Recommendation Report for Planning Permission for Works or Extension to a Dwelling

REF NO: AW/381/21/HH

LOCATION: 27 Faresmead
Aldwick
PO21 3DQ

PROPOSAL: First floor rear extension.

SIDE ELEVATION (SW)
1-100

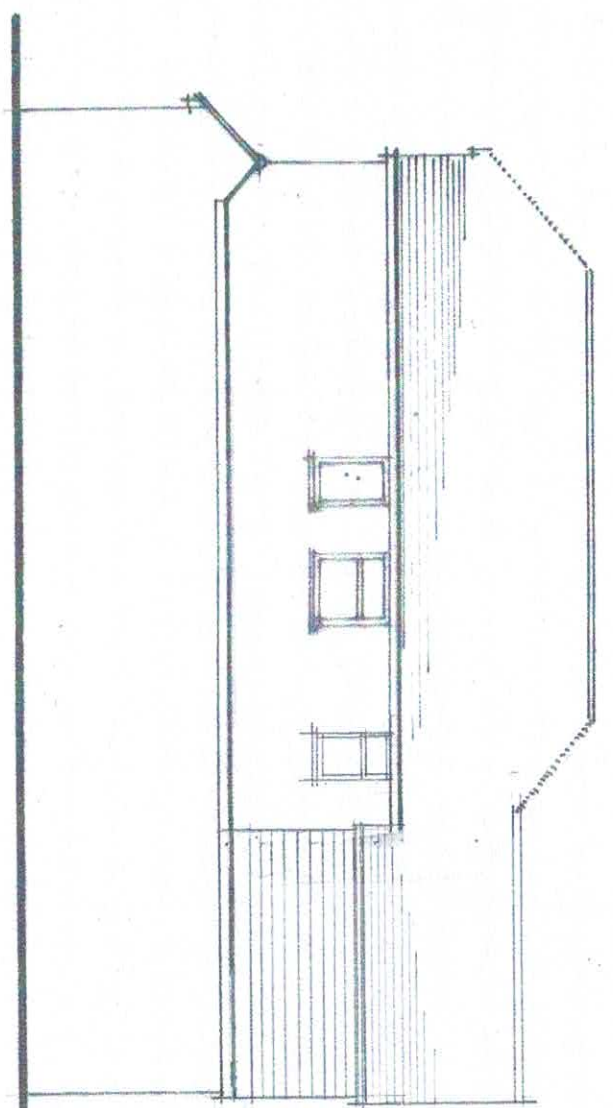
There will also be an additional window to the west serving bathroom and will be obscured glazed.

- 4 The first floor window on the western elevation of the building shall at all times be glazed with obscured glass and only openable at a high level, at least 1.7m above finished floor level.

FIRST FLOOR PLAN
1-100
Roof Plan Dotted
7.0M
D BOUND

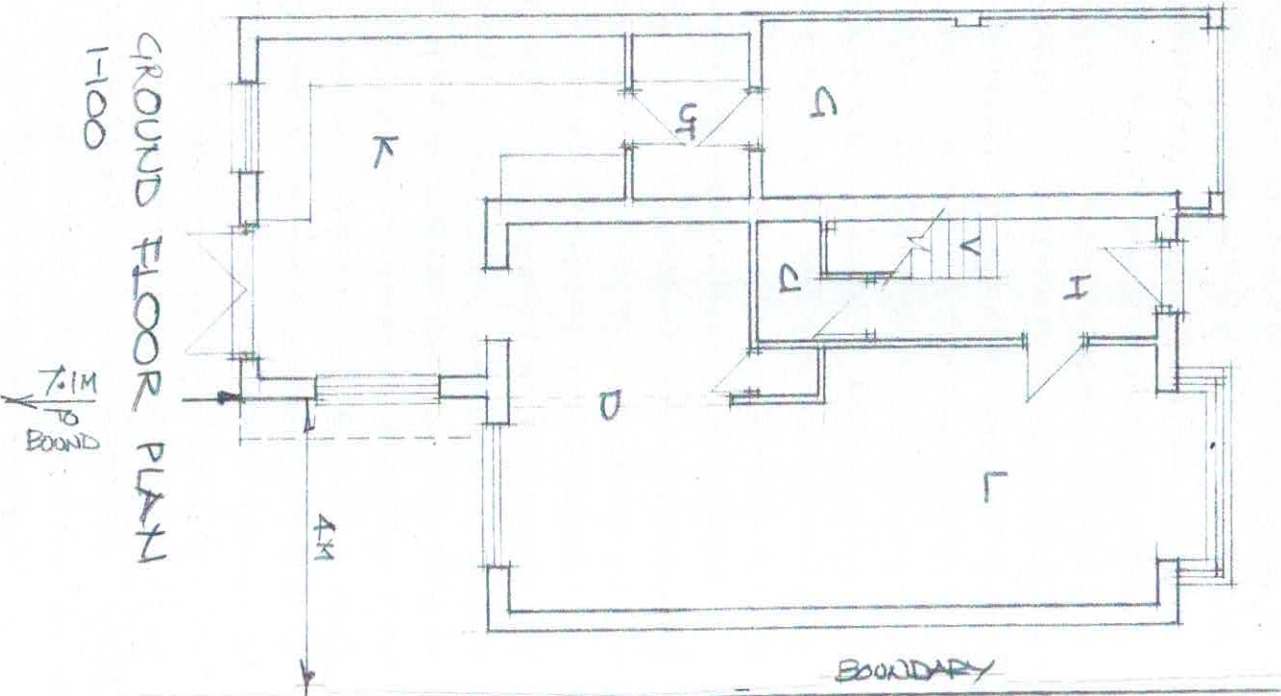
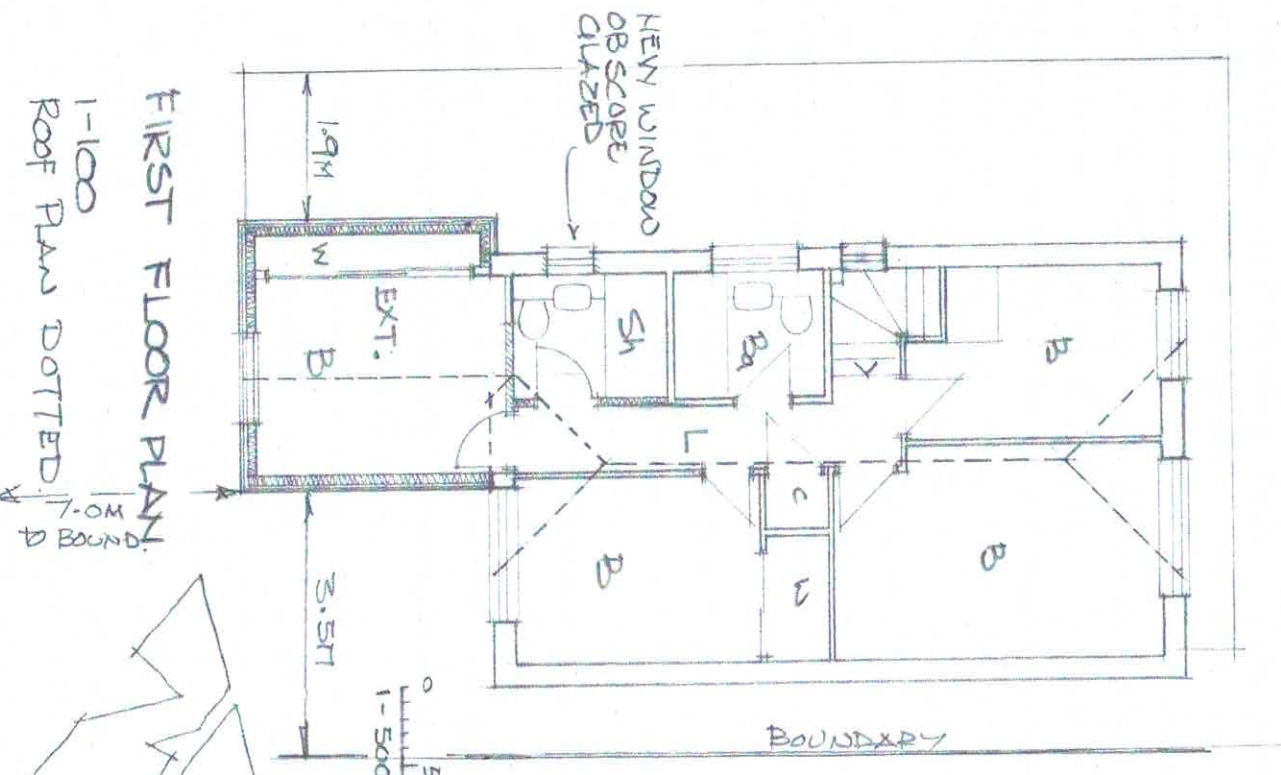
The extension will have a depth of 3.5m. This retains 3.5m to the eastern side and 1.9m to the western side.

There will be a bedroom window which replaces an existing, albeit sited further towards the rear. With the host dwelling having a relatively short rear garden depth of 7.1m the extension will give rise to some overlooking upon the properties to the rear specifically 17 Wyde Feld. This is not considered significant in which a refusal is justified as a result of the rear properties being located at an angle, and as such the line of sight is not direct and with sufficient planting along the boundary to the rear neighbour this helps to restrict views.
